From: Robert Findlay
Sent: 25 September 2012 12:02
To: Planning.Responses
Subject: FW: Planning Consultation on: LU/146/12/

APPLICATION	LU/146/12/
NO:	
Registered:	19th September 2012
Site Address:	12 St. Catherines Road Littlehampton West Sussex BN17 5HS
Grid Reference:	502921 101777
Description of Works:	Proposed conversion of existing vacant dwelling into 6 no. self contained residential units

Proposed first floor plan. Scale 1:50

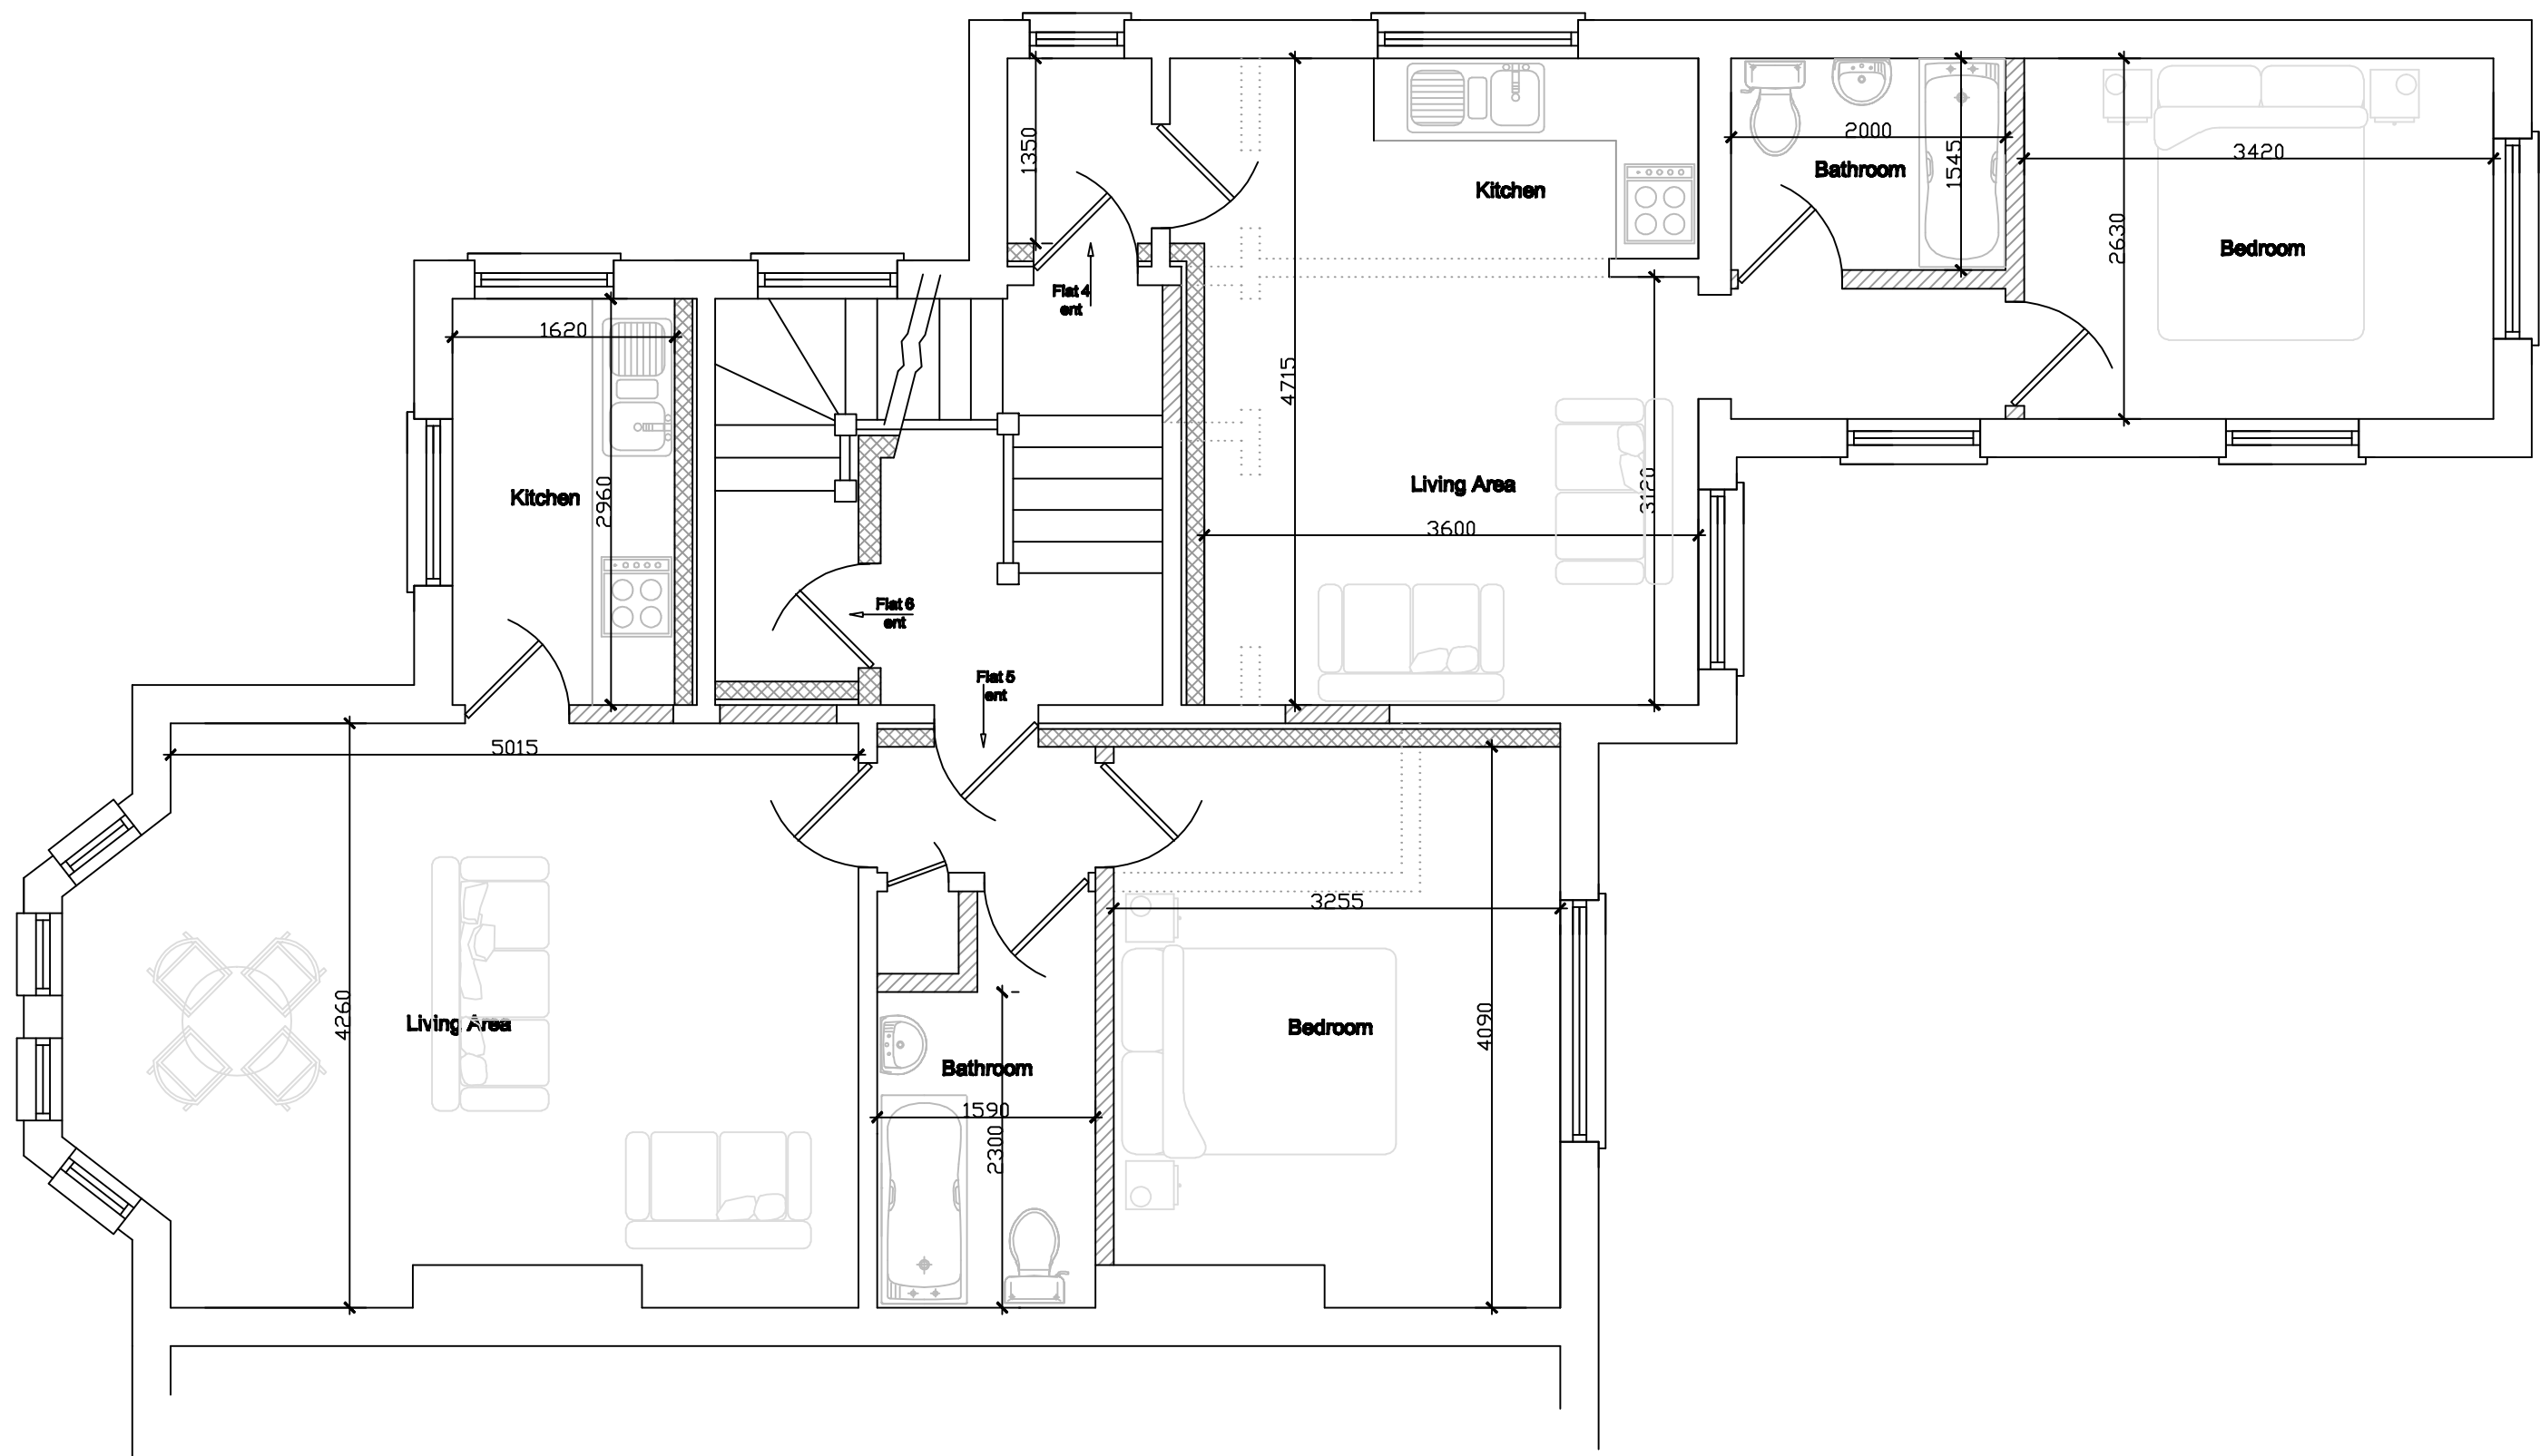
Flat 4

The bedroom size would limit occupation of this flat to 1 person only

Flat 5

The kitchen appears to be below the minimum recommended floor area of 5.5sqm.

Proposed ground floor plan. Scale 1:50

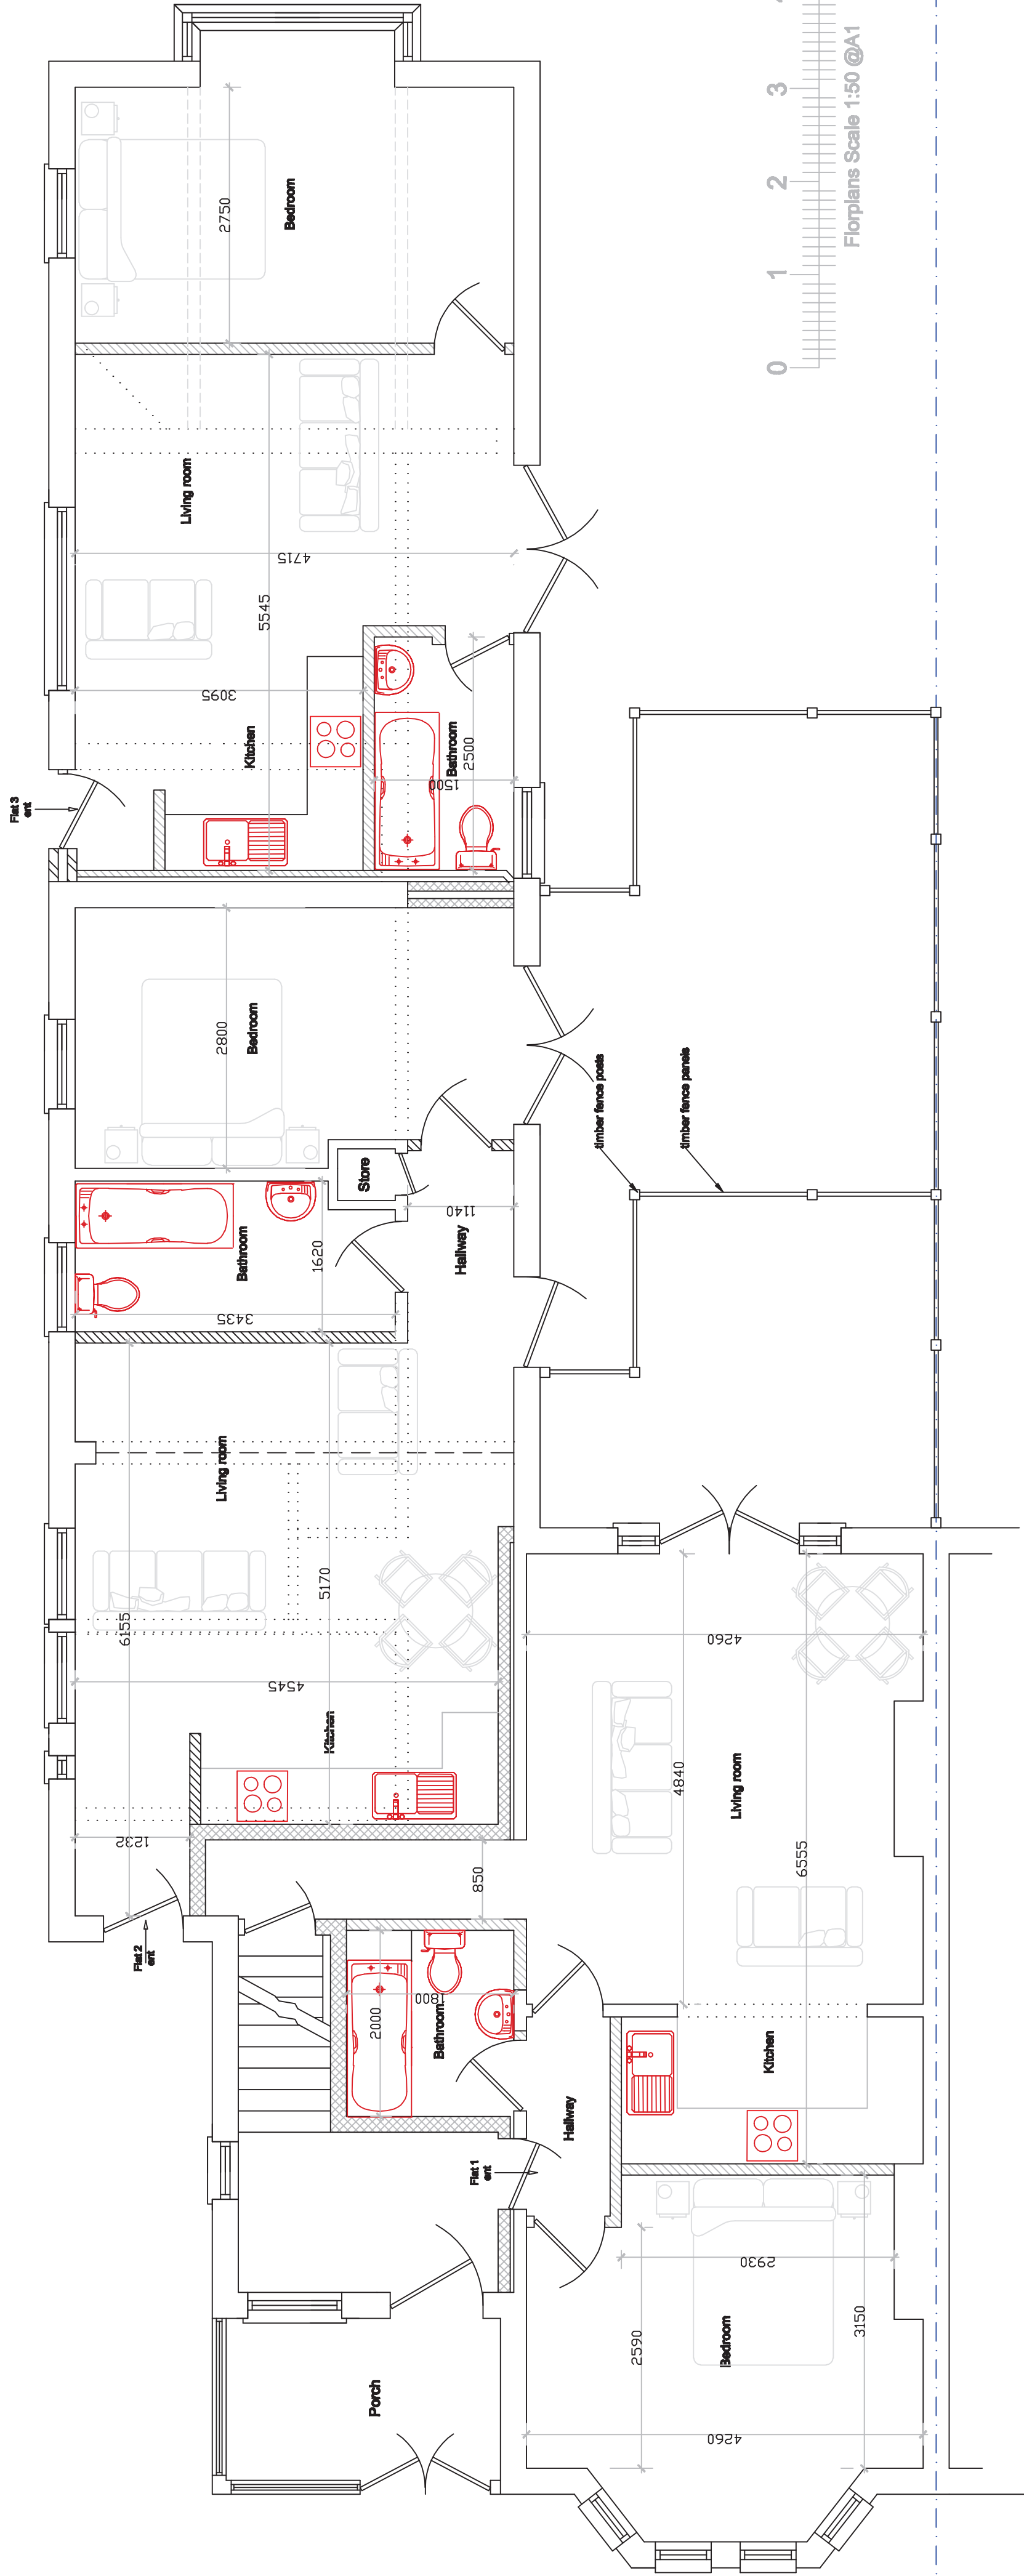
Flat 1

There appears to be inadequate provision of natural lighting and ventilation to the living room /kitchen of the flat. The use of patio style doors is not considered adequate for natural lighting or ventilation. For lighting the glazing is to be equivalent to 1/10th of the floor area of the room and ventilation to be by openable windows with an openable area equivalent to 1/20th of the floor area.

Flat 3

Means of escape windows are required for the bedroom as means of escape is via another room of significant risk in the event of fire.
